From: Simon Davis
Sent: 17 February 2020 13:14
To: Ben Daines [REDACTED]
Cc: Chris Barker [REDACTED]
Subject: RE: BE/137/19/RES The Cottage, Shripney Road

Drawing Title
Proposed Plans & Elevations, Plots 1-6

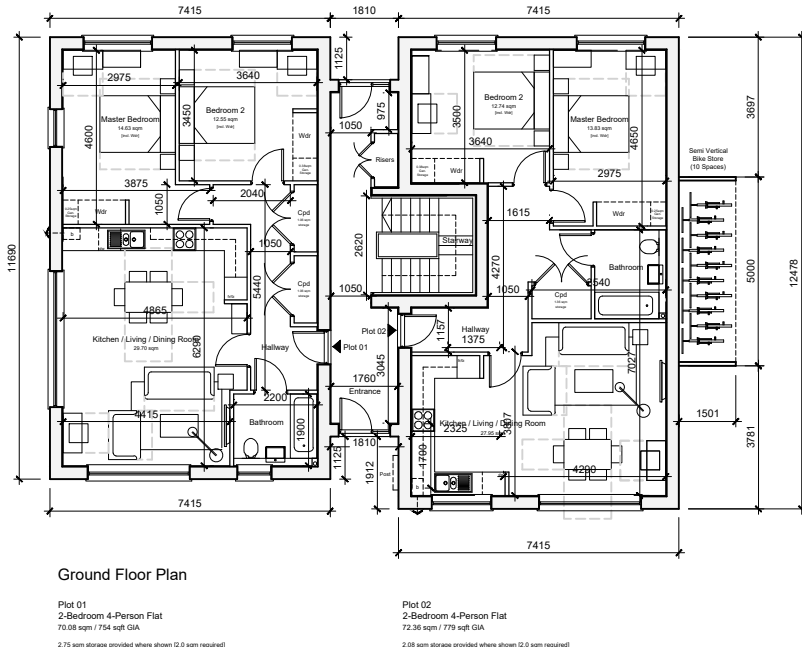
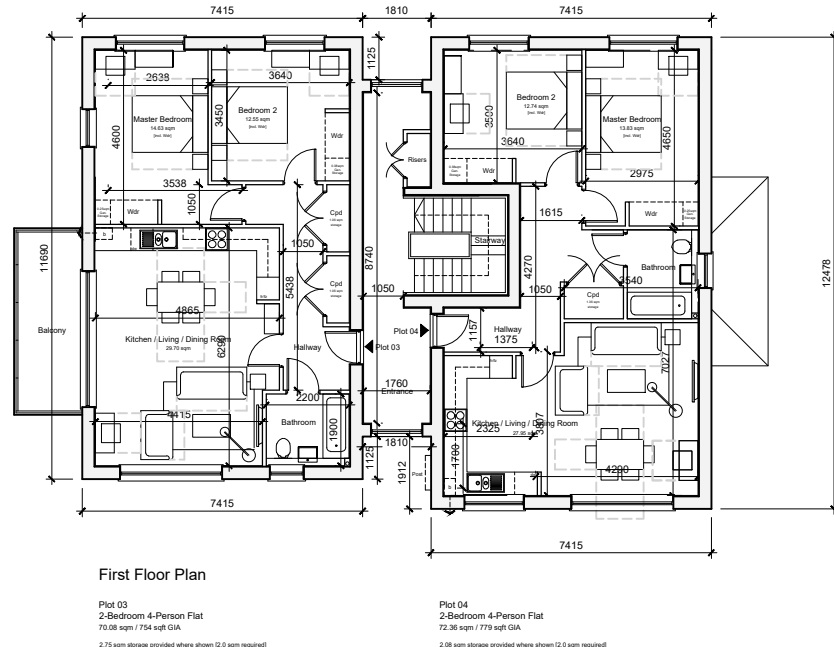
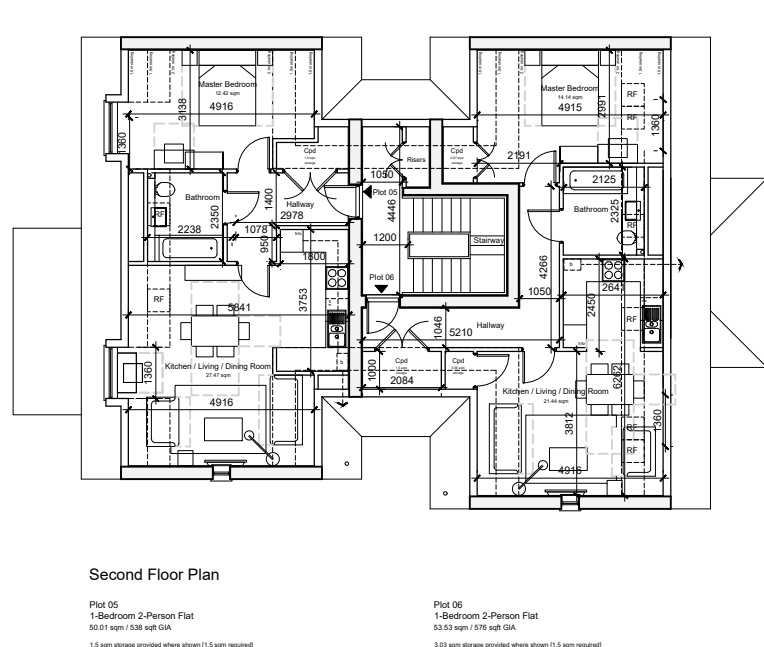
- (1) I can't tell what the sill height is of the master bedroom velux windows of flat 6 which face east. We would need these to be 1.7m as otherwise there would be clear views over the adjoining garden. The corresponding bathroom window is ok as it can be o/g but we would not want to do that for the sole windows to a bedroom.
- (2) I cannot find anywhere (in the D&A or on the plans) what the amount of POS is in m2. Please advise and also indicate how much there is for each of the two areas.
- (3) Can you advise why the need for the footpath between plots 18 & 19? If this were removed, you could gain an extra parking space at the eastern end.
